RE: 25 DUNHEVED CIRCUIT, ST MARYS – TRAFFIC IMPACT ASSESSMENT PEER REVIEW

GTA Consultants (GTA) has been engaged to complete a peer review of the Traffic Impact Assessment (TIA) prepared by The Transport Planning Partnership (TPPP) dated 26 November 2020 to accompany the State Significant Development Application (SSD-10474) for 25 Dunheved Circuit, St Marys.

Figure 4.1: Trip Generation Comparison

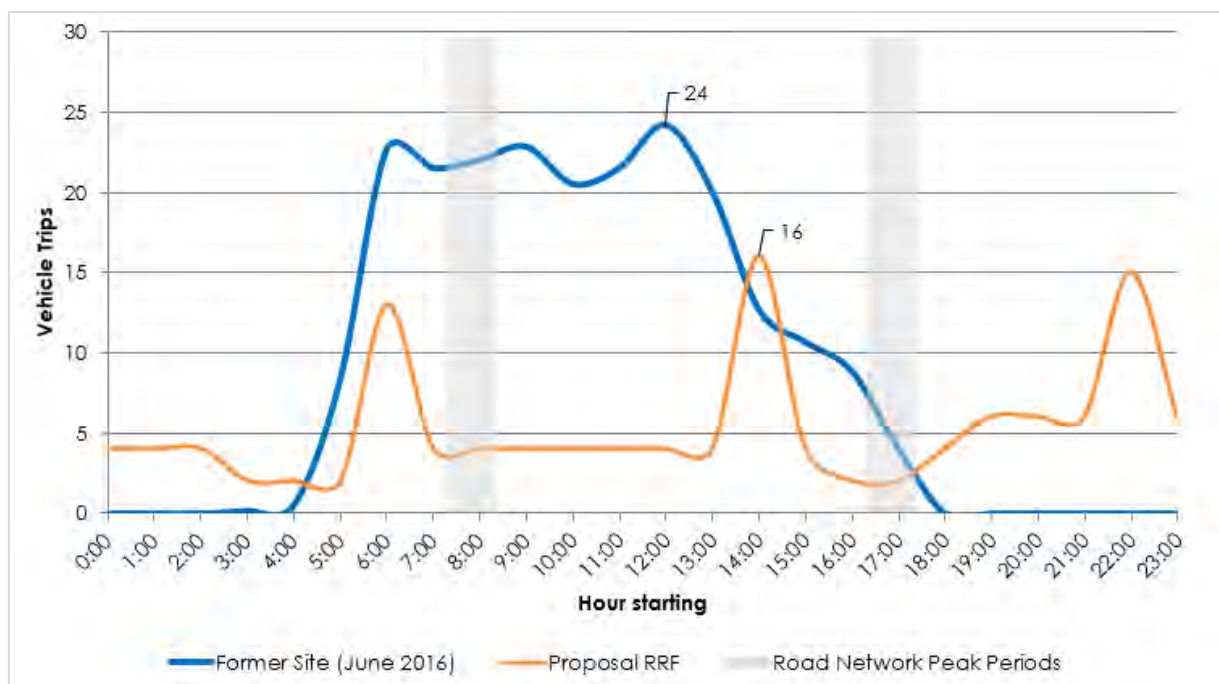
- Figure 4.1 of the TIA (TTPP, 2020) indicates that the proposal would generate less vehicle trips than the existing use for the site for most of the day except in the afternoon shift changeover period (site peak hour). On-site observations confirm extensive queuing on Dunheved Circuit and Links Road on approach to the Forrester Road/ Ropes Crossing Boulevard/ Links Road roundabout from early afternoon (see Figure 3). This is a result of vehicles departing the area and is typical for industrial precincts where the peaks occur earlier than the broader road network peaks. Given the afternoon peak generation of the site (including the 16 vehicle spike around 2pm and 2:30pm), traffic modelling would appear appropriate at these times at these key intersections to understand the true traffic related impacts of the proposal.

- Traffic modelling during the early afternoon peak should be considered, and at the time when the site generates most traffic and the road network in the precinct appears to also experience delay.

Site Plan

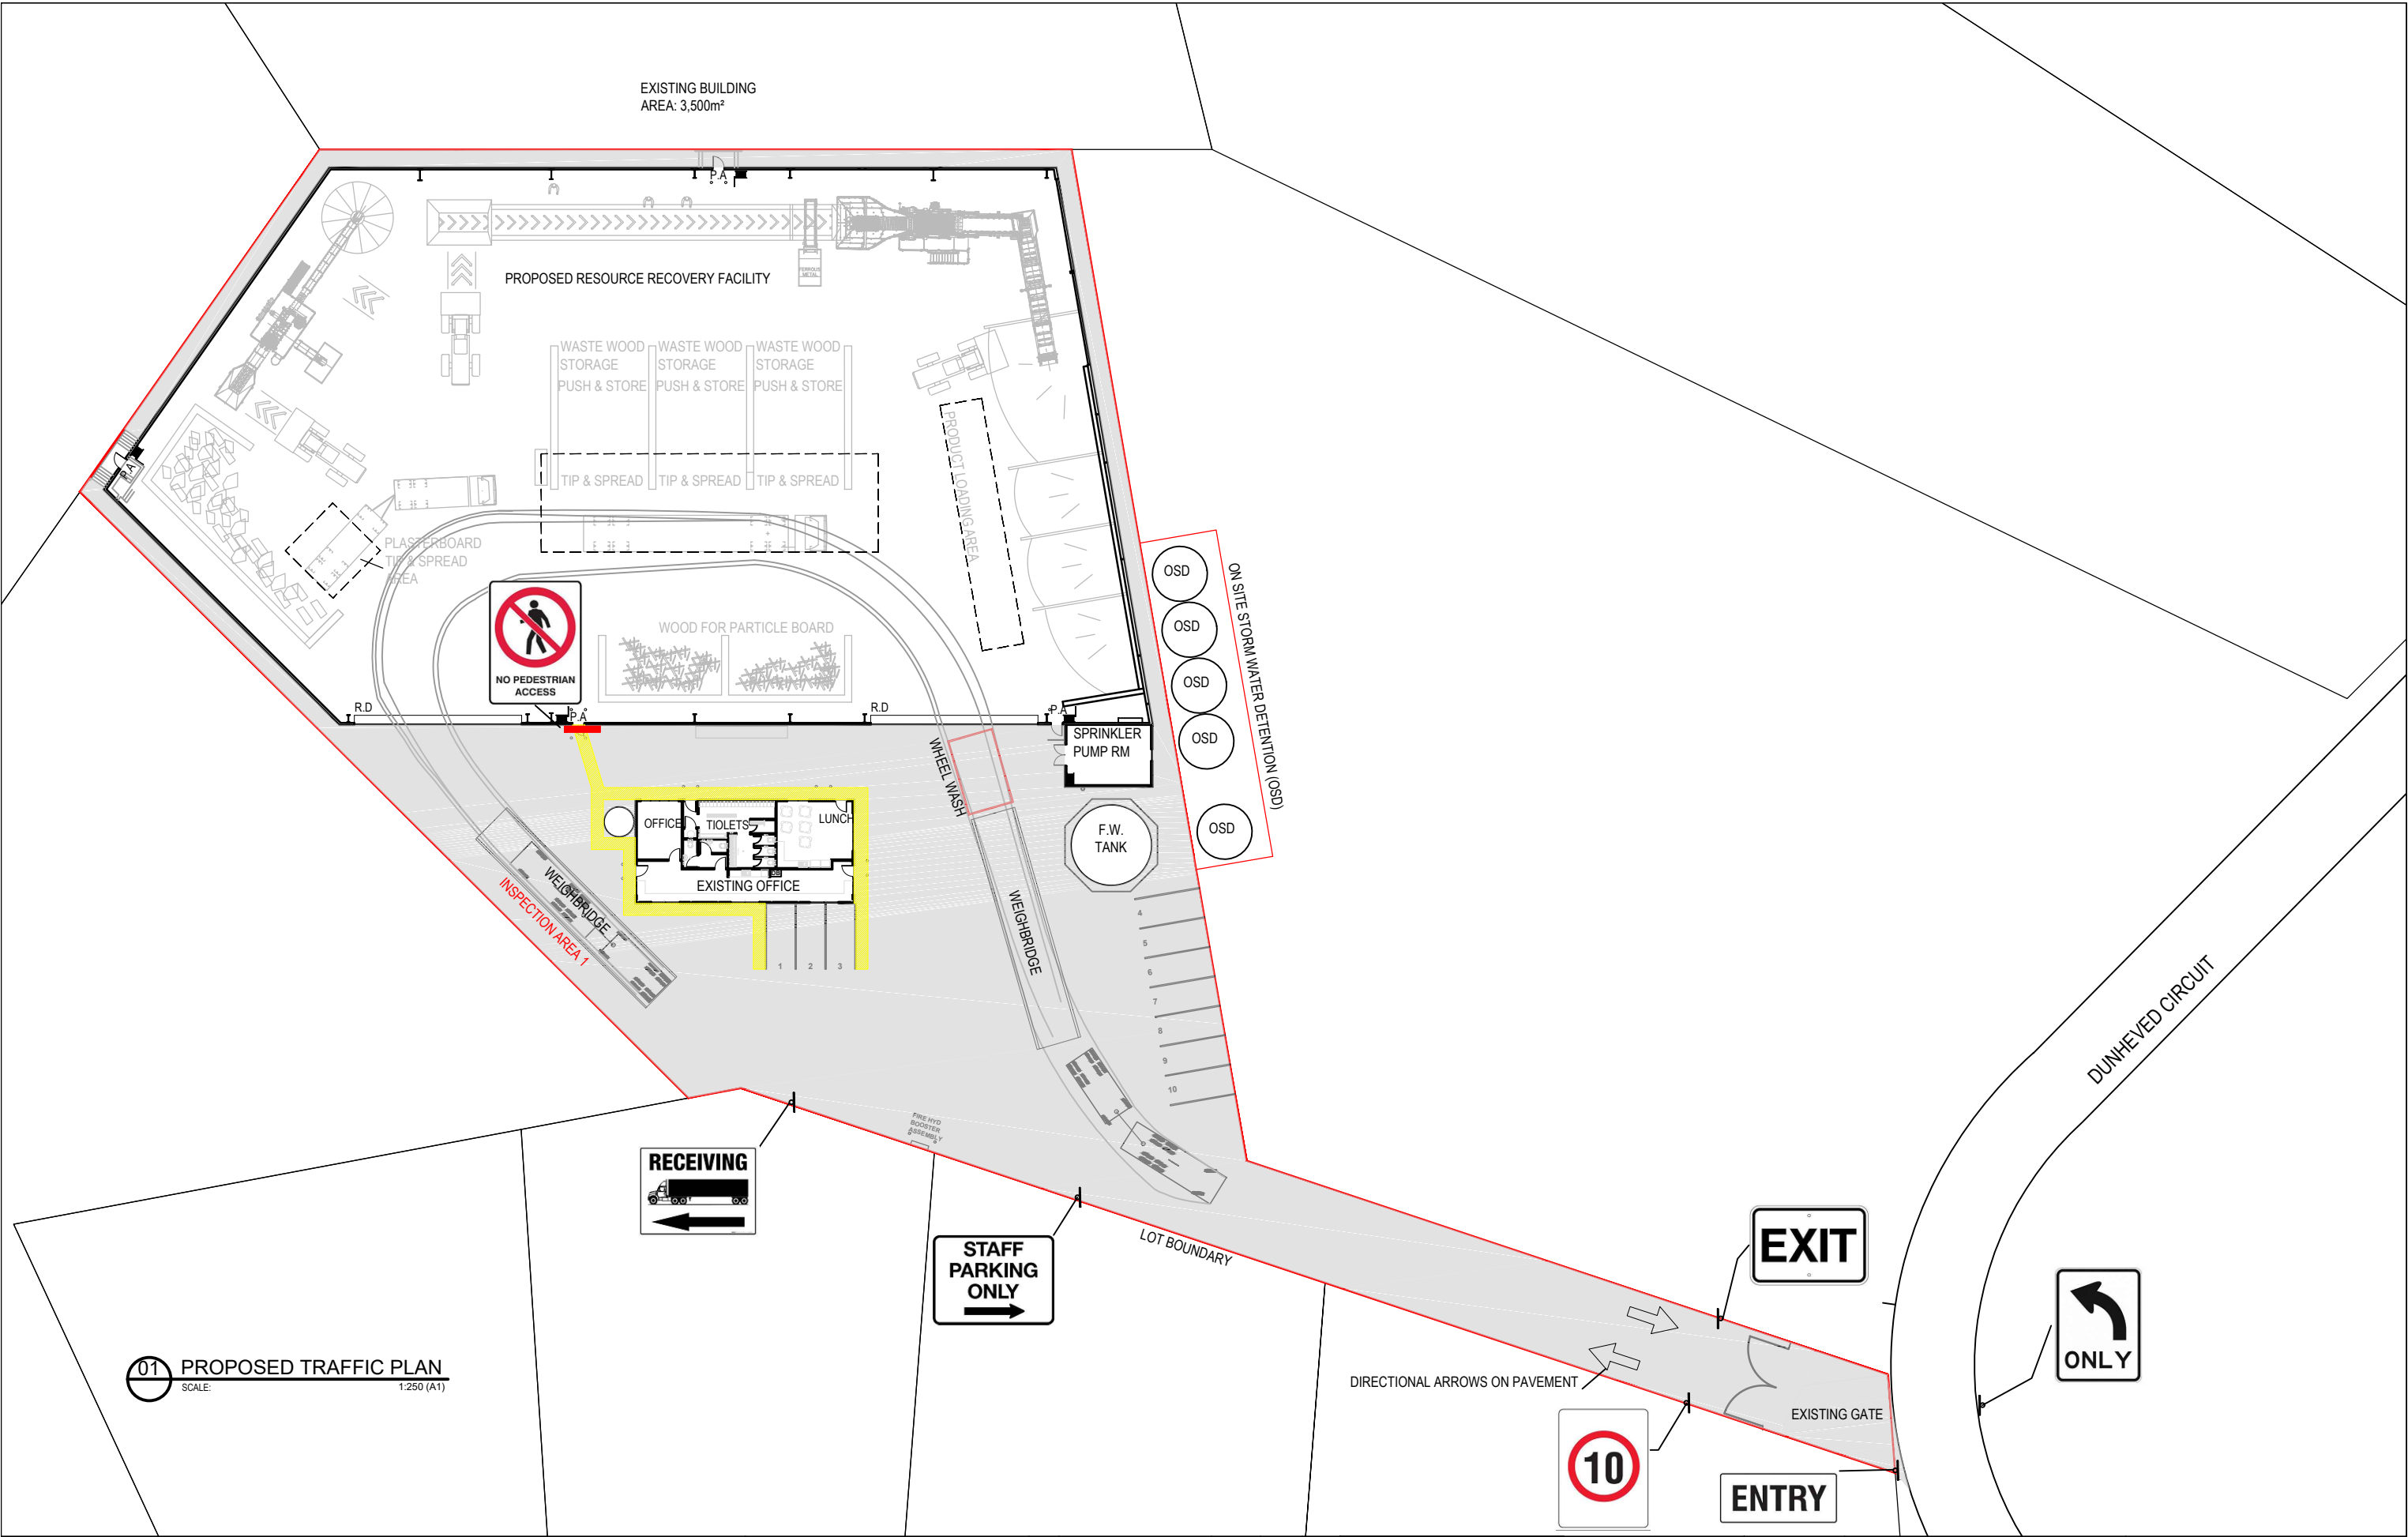
- The swept path assessment included in Appendix D of the TIA indicates articulated vehicles exiting the site onto Dunheved Circuit would conflict with existing on-street parking currently permitted along the 21 Dunheved Circuit site frontage. The TIA does not mention any proposed loss of on-street parking as a result of the proposal or the associated impacts. This is a critical detail and should be appropriately addressed – vehicles parking in this location would be struck or trucks would mount the kerb on the other side to avoid such conflict. The issue primarily arises due to the larger size of vehicle required to access the site when compared with previous uses.

- Articulated vehicles also need the full width of Dunheved Circuit to exit the site. With Dunheved Circuit being narrow (about 7.5m wide) and somewhat unique for an industrial precinct where road widths are typically 10m to 13m wide, this further constrains the site access requirements and on-street parking conflicts. There would clearly be conflicts with arriving and departing vehicles and through traffic on Dunheved Circuit should any small delay occur and/ or an articulated vehicle has difficulty exiting the site.

- The swept path assessment indicates that an articulated vehicle exiting the site would also be required to traverse the 21 Dunheved Circuit driveway when turning left onto Dunheved Circuit. Such arrangements are typically not accepted given one site is reliant on the adjacent site to maintain their access arrangements. While it is understood that the 21 Dunheved Circuit is owned by the same organisation as the subject site, the 21 Dunheved Circuit site could be sold in future and potentially redeveloped and hence again, alter the current access arrangements.

- A 300mm clearance is shown on the swept path assessment for articulated vehicles which is not in accordance with the general 600mm requirements of AS2890.2:2018. This further shows the inappropriateness of the driveway to accommodate passing trucks along its 100m length.

- The swept paths should be updated to consider existing kerbside parking currently permitted along Dunheved Circuit and detail any proposed loss of on-street parking and the associated impacts of such loss.

- The swept paths should be updated to demonstrate independent access is possible and without reliance on the adjacent 21 Dunheved Circuit driveway.

- The swept paths should be updated to allow for 600mm clearances in accordance with the requirements of AS2890.2:2018.
